Your Ref: OWPC10949
Our Ref: WA/63/16/PL 26-08-2016
Please ask for:
Mr D Easton

Demolition of 3 No. existing agricultural buildings & erection of new agricultural building
& farm workshop/office.

Fairmead Farm Binsted Lane Arundel

Thank you for your internet representation made on 19th October 2016 which has been
recorded as '**an objection**' with the comments as follows:

DRAWING Proposed new farm machinery
and equipment store

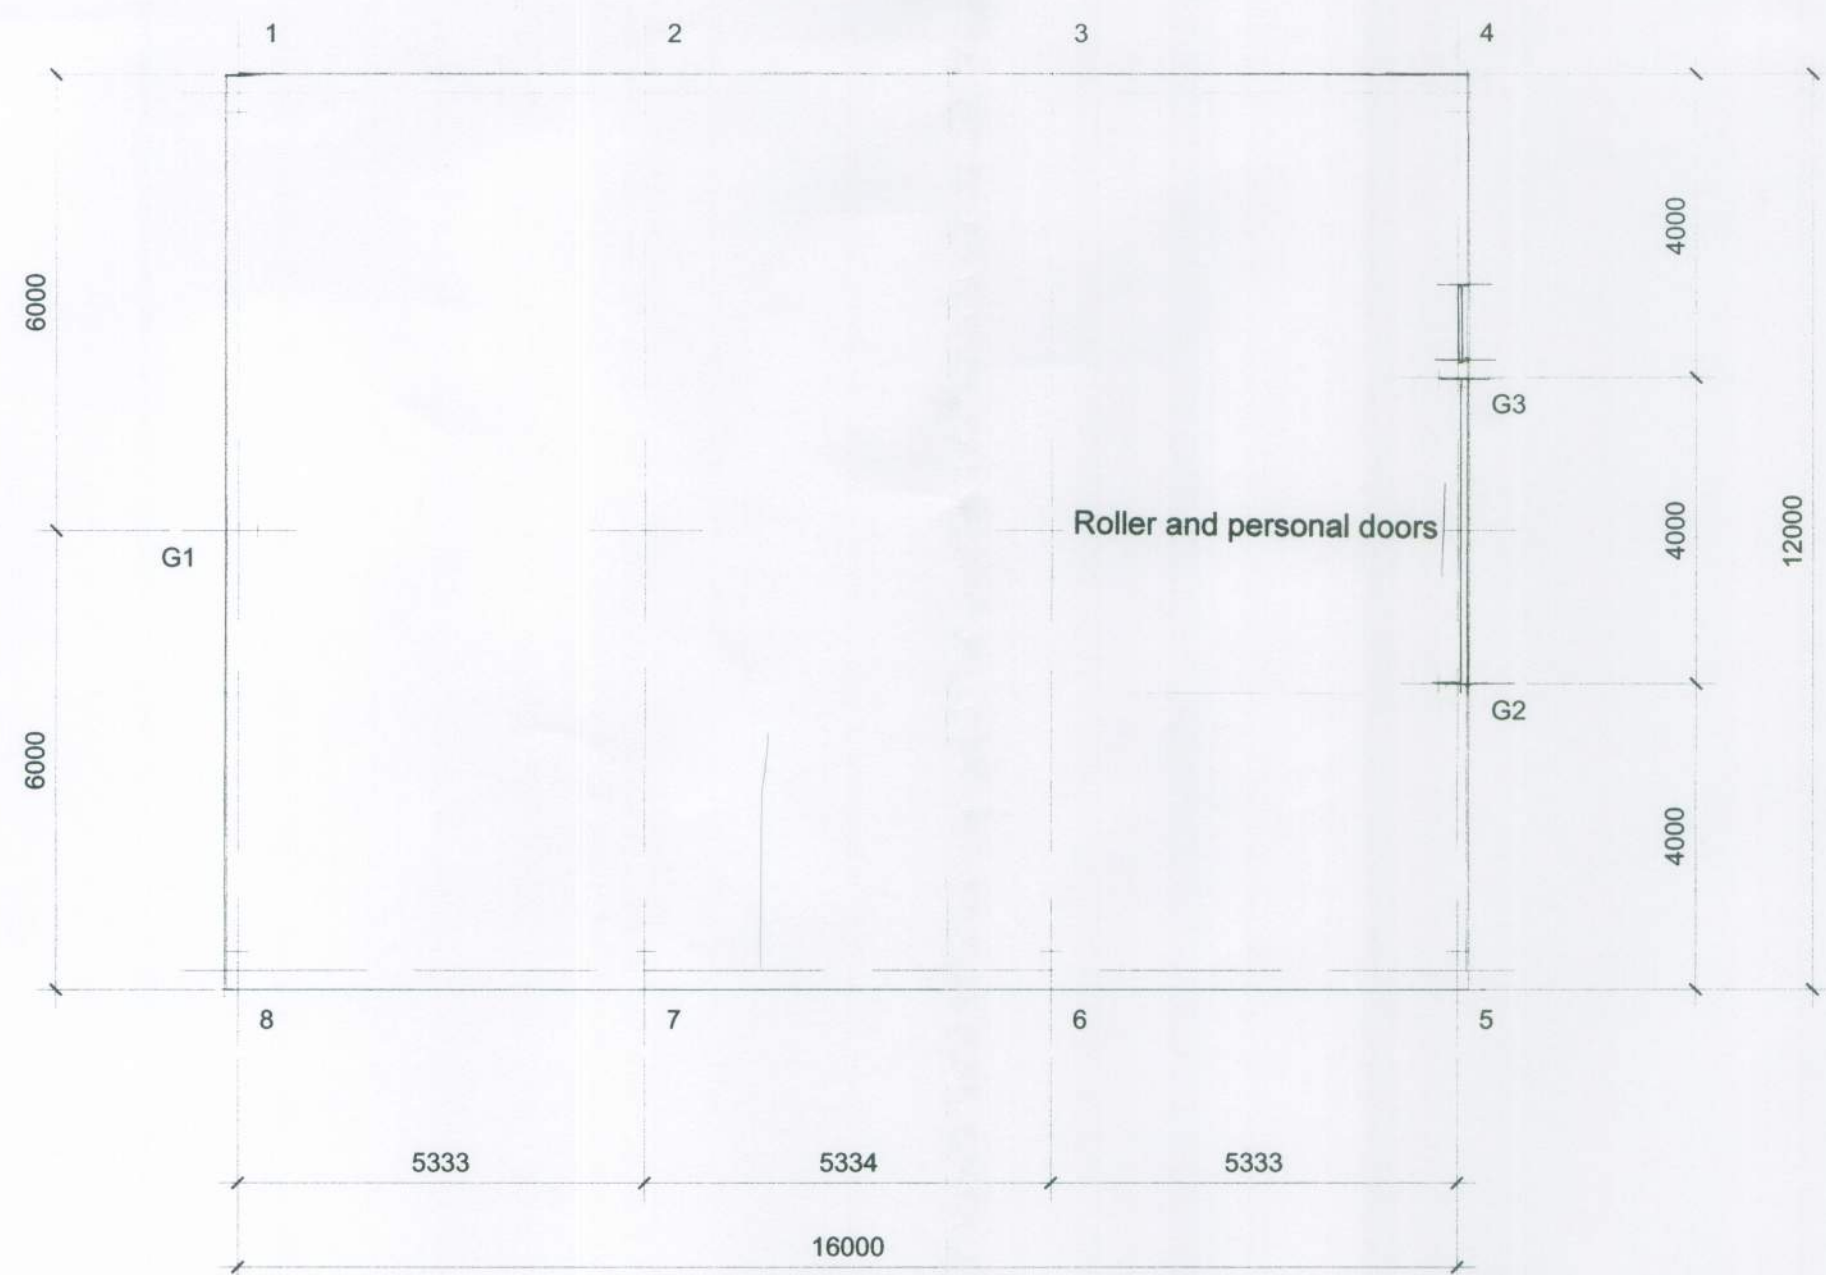
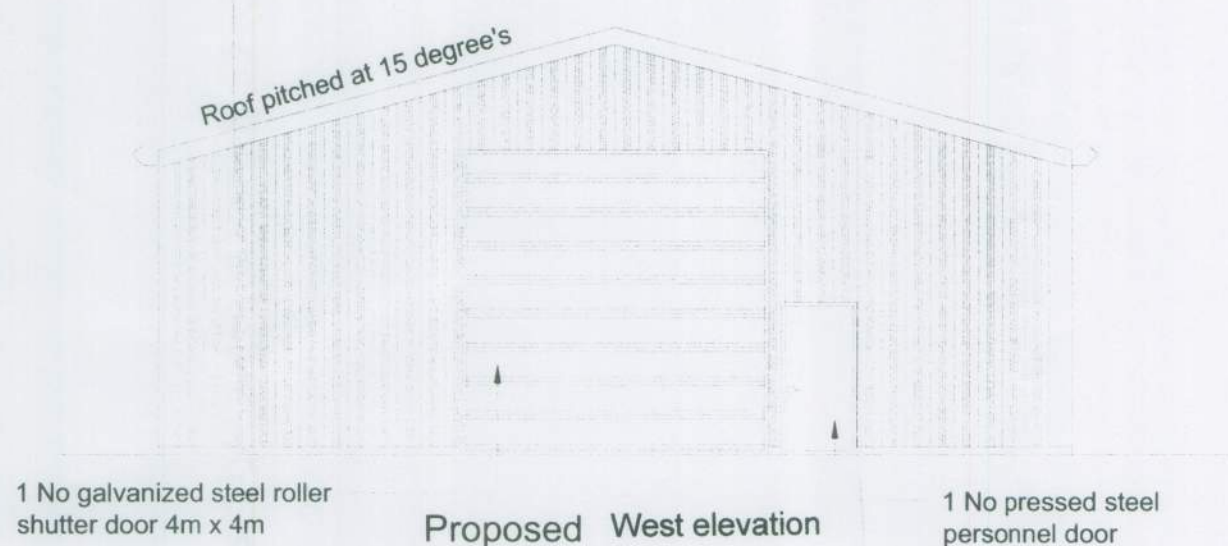
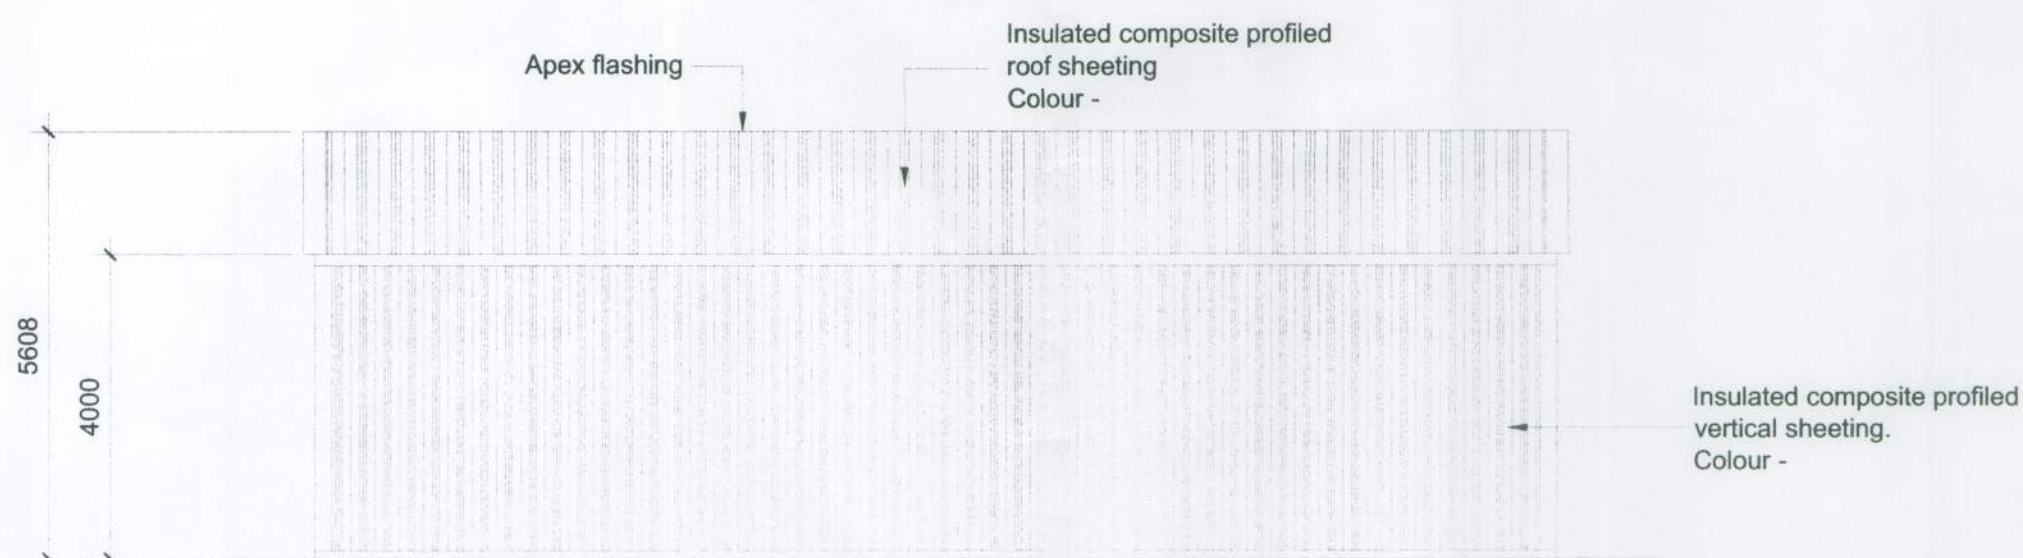
The interpretation of "replacements of existing dilapidated buildings" given by the applicant is incredulous. We would question how a single story low roofed turkey/chicken shed can be 'replaced' with a structure over 8 metres high. The impact of this proposed structure would be very intrusive and clearly visible on the skyline from the National Park and beyond. It would be visible from both Tortington and Ford. Its presence would also block the eastern view from the public footpath on Parish Piece across the open field toward Tortington and the Arun Valley. A structure of this type and dimension is not in keeping with other buildings in the village.
